**BLOCK 4N CENTRAL PARK – Section 96 Submission  
ARCHITECTURAL DESIGN STATEMENT**

20th January 2016

SOFTWARES PLAN
LEVEL 12-16

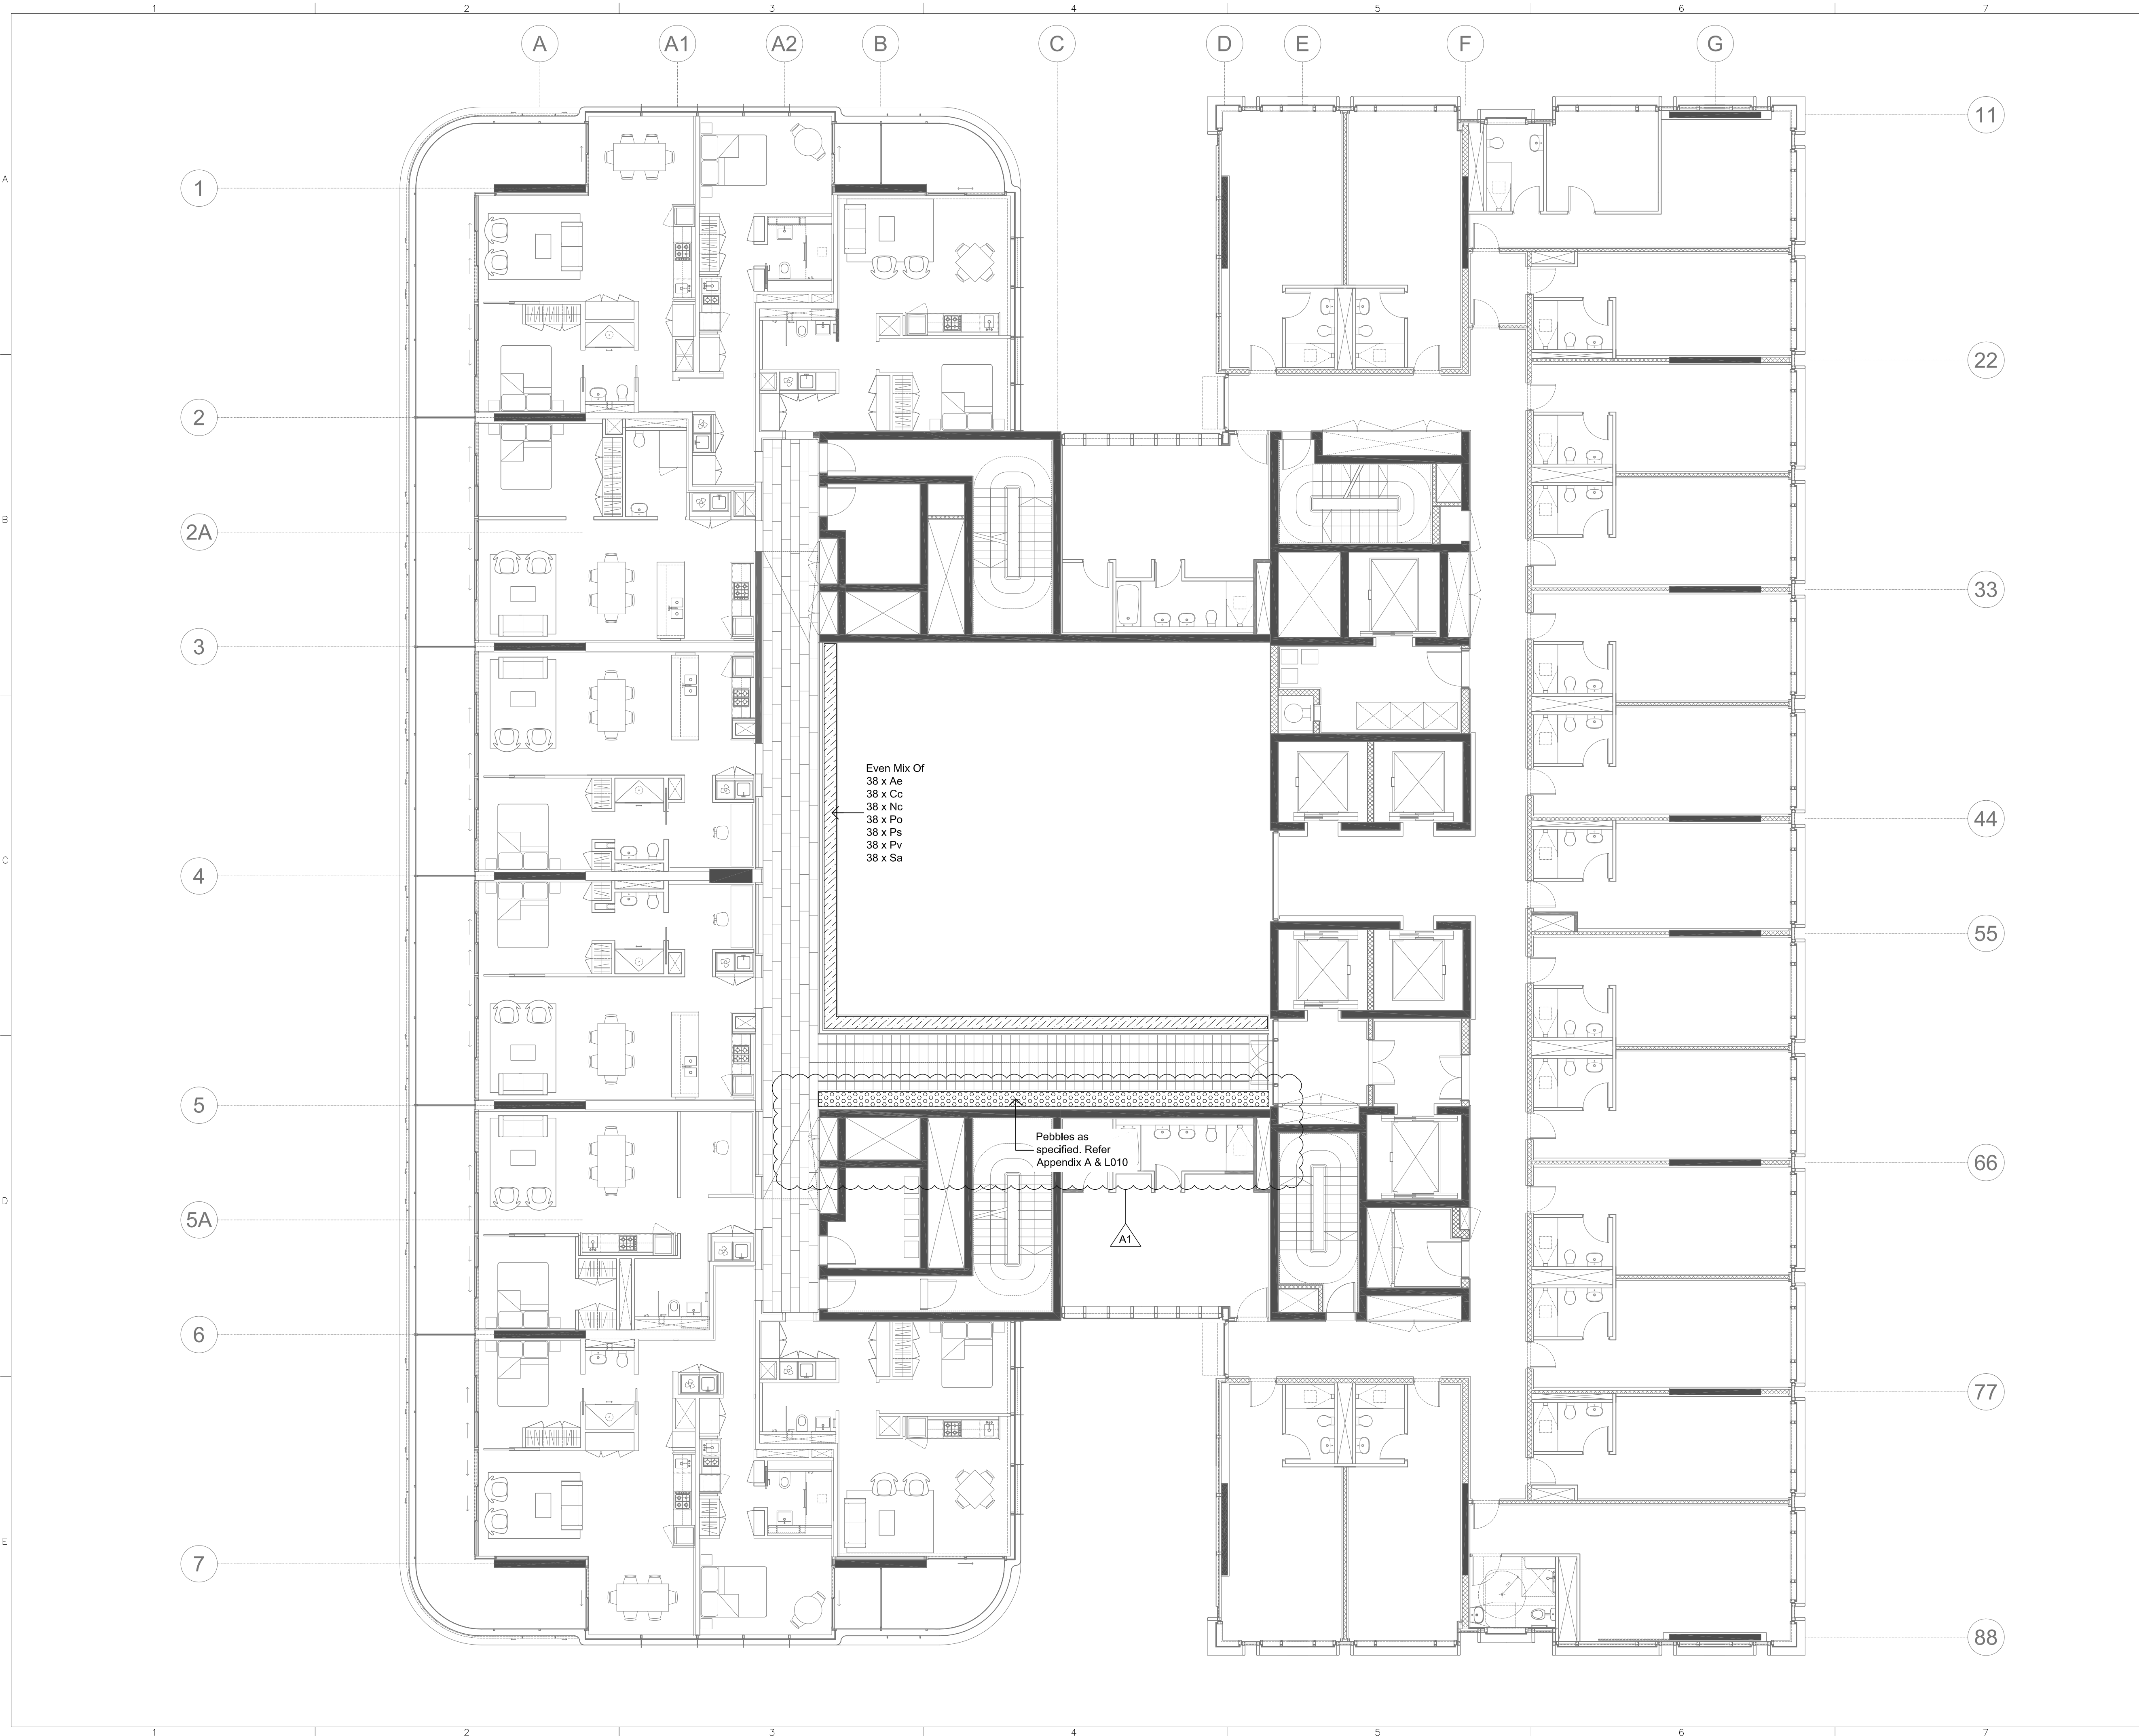
The pedestrianised street between Block4N and Block1 is intended to be a key focal point between the two buildings, and is also an integral element of the whole Central Park urban design precinct. Following our recent additional design studies, the proposed modification to the SSDA design is to replace water features with additional soft landscaping> The specific design details and planting proposals are as shown in the landscape design documentation provided by JAAA+TDS.

The new landscaping elements along the Block4N hotel entrance facades, consist of raised garden beds with dense shrubs (Japanese Aralia, etc) and with natural gravel used as a groundcover along their edges. The carefully designed soft landscaping elements will define the space and maintain a degree of separation and privacy. The additional planters are proposed to be raised up from the ground in some areas. Careful selection of plant species that can grow tall, will provide the adjoining Hotel terraced areas screening and visual interest from the rest of the landscaped footpath areas used by the general public.

Together the raised fixed seating elements with complementary feature paving, and the feature trees and shrubs proposed allow this landscape design to continue to define the distinctive character of the 'Pedestrian Street' between both Buildings.

Block 4N
West Elevation (04)
Abercrombie

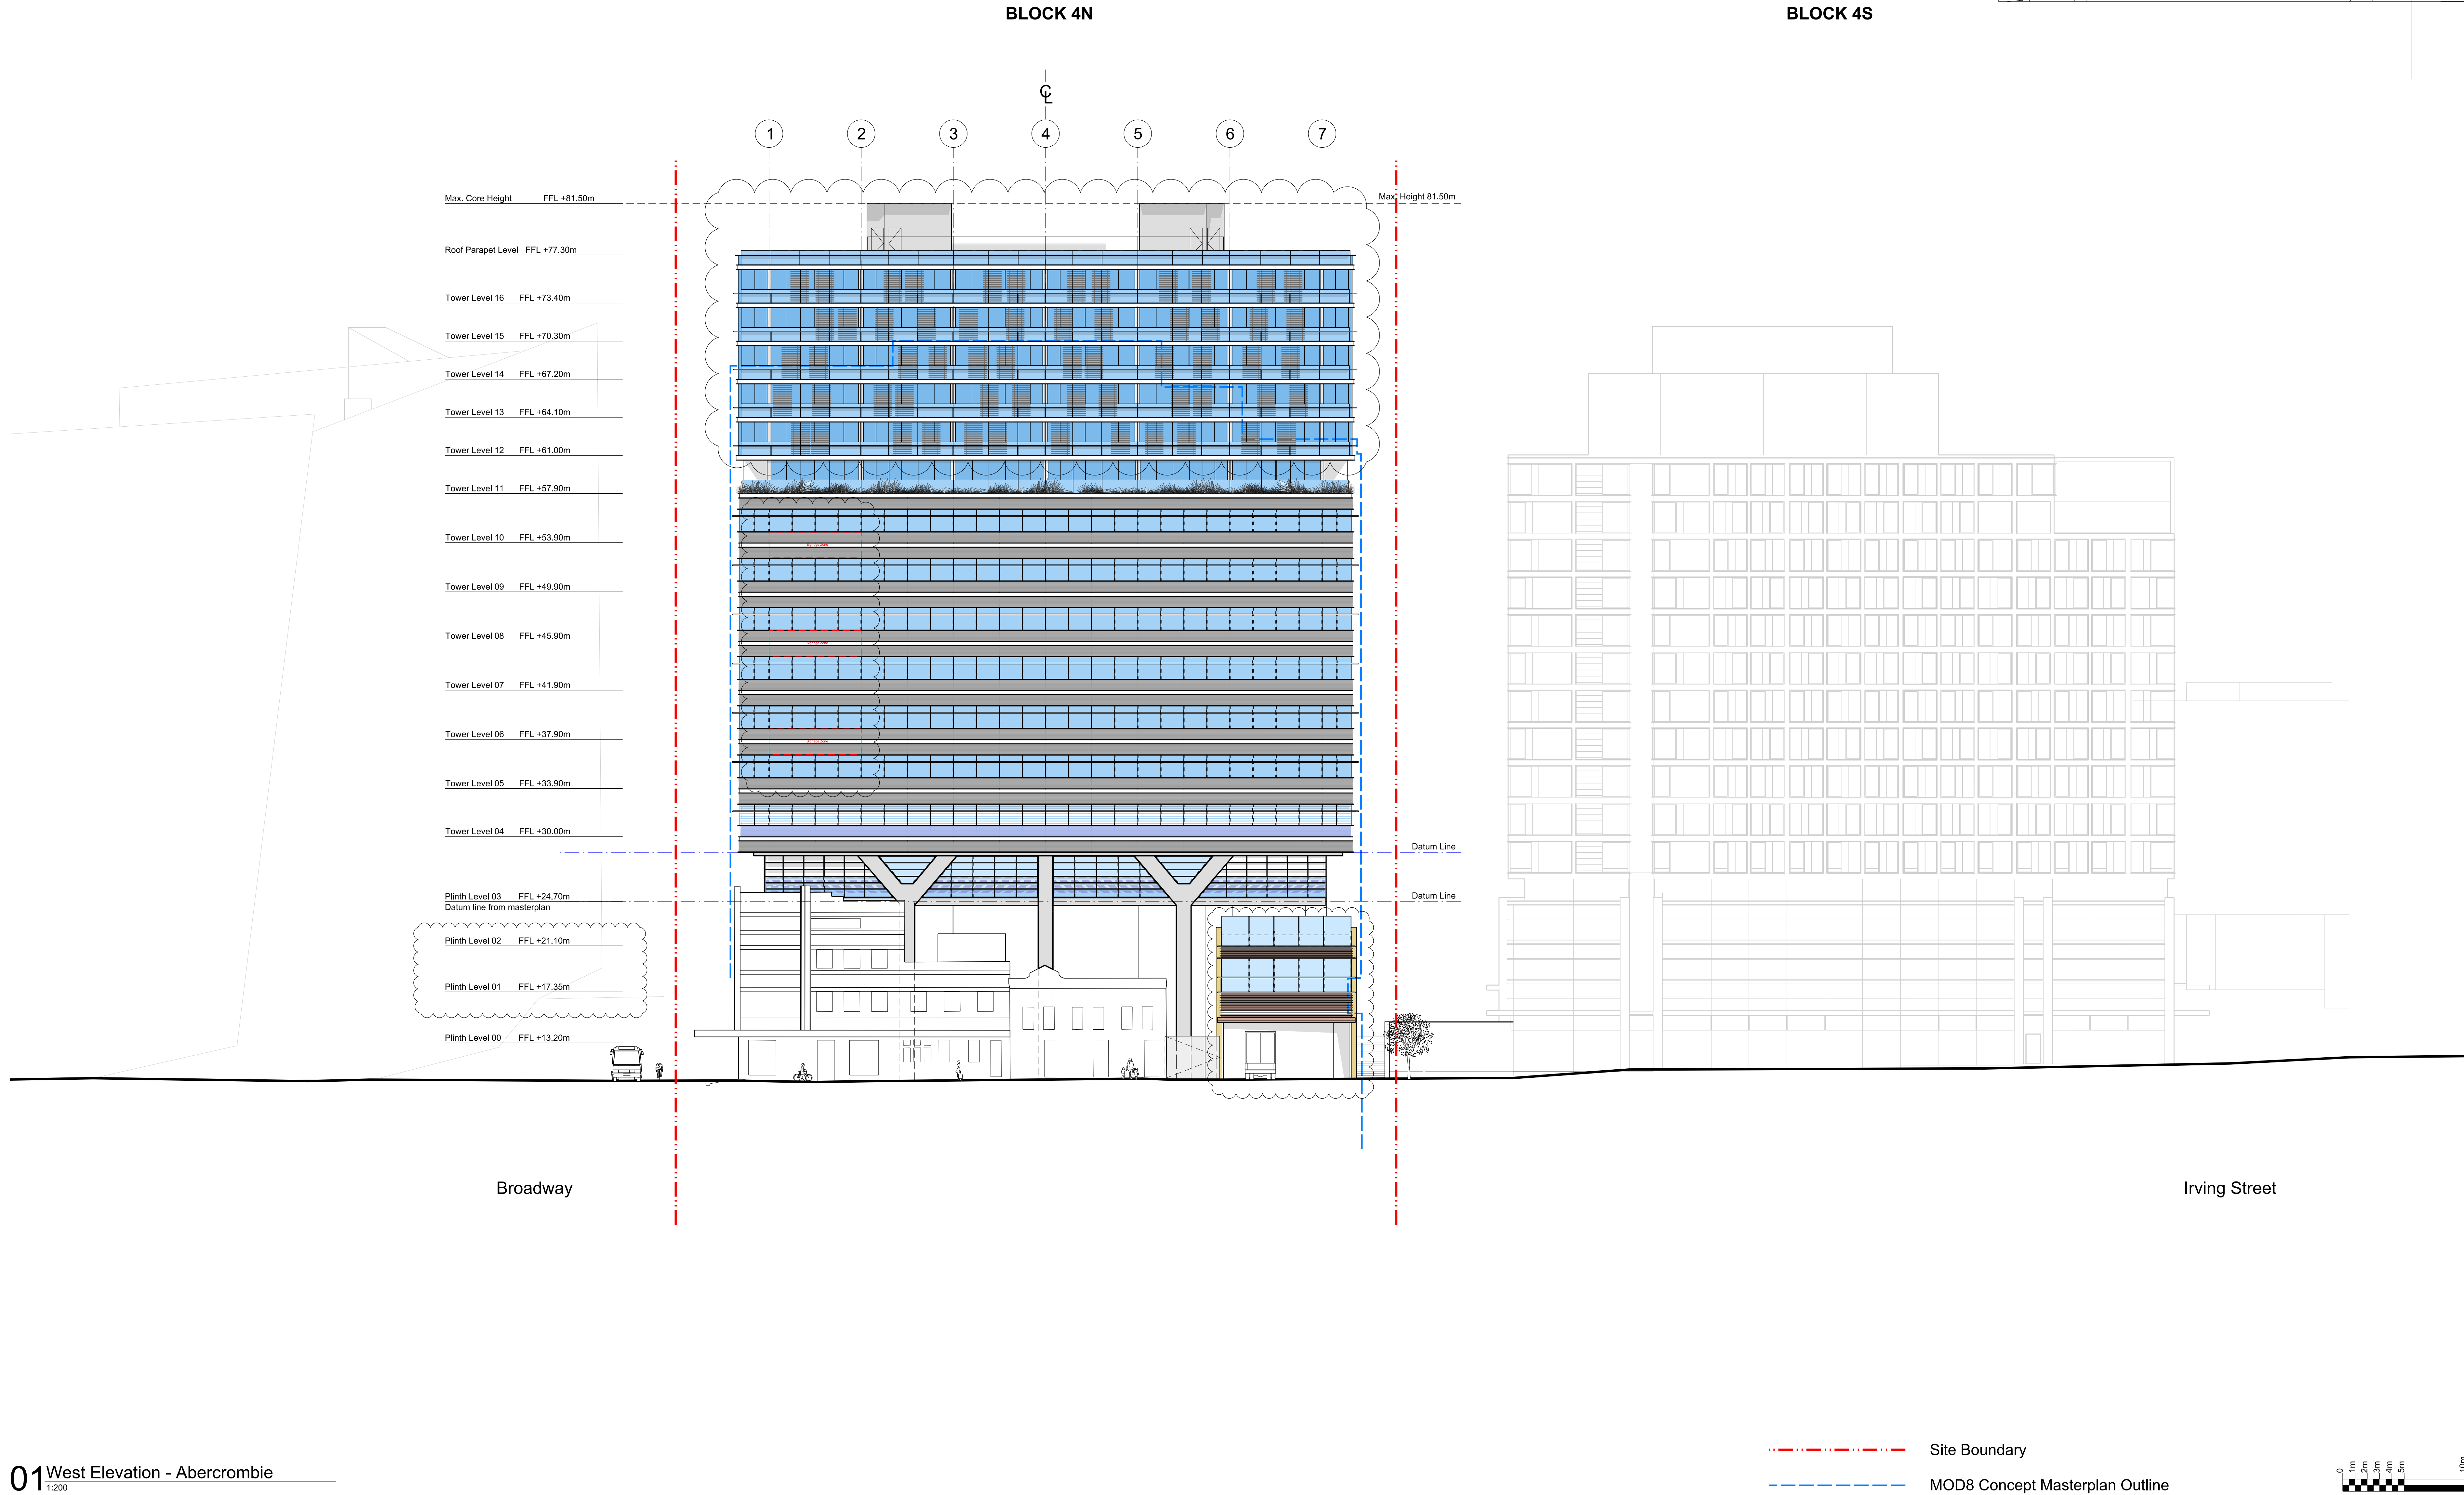
In order to facilitate an increase in the hotel area requirements, a new 'minimal' glass bridge has been incorporated to link between the main hotel podium and the south-western pavilion on Abercrombie. This bridge will provide direct links between the conference facilities on level 01 with new sanitary facilities within this annex, and has the remaining area split between a dedicated hotel administration areas and a small Gym. On level 02 the hotel and conference facilities will now also have a connection out onto the external roof terrace of the annex. Please also note that taller glass balustrades have been incorporated on the South-Western corner to mitigate any potential negative wind effects.

In order to create a column-free, and 'see-through' transparency; Clear glass facades on the North and South are substituted with a full height concrete wall on the West supporting the roof structure which is placed in line with the retail canopy on Broadway.
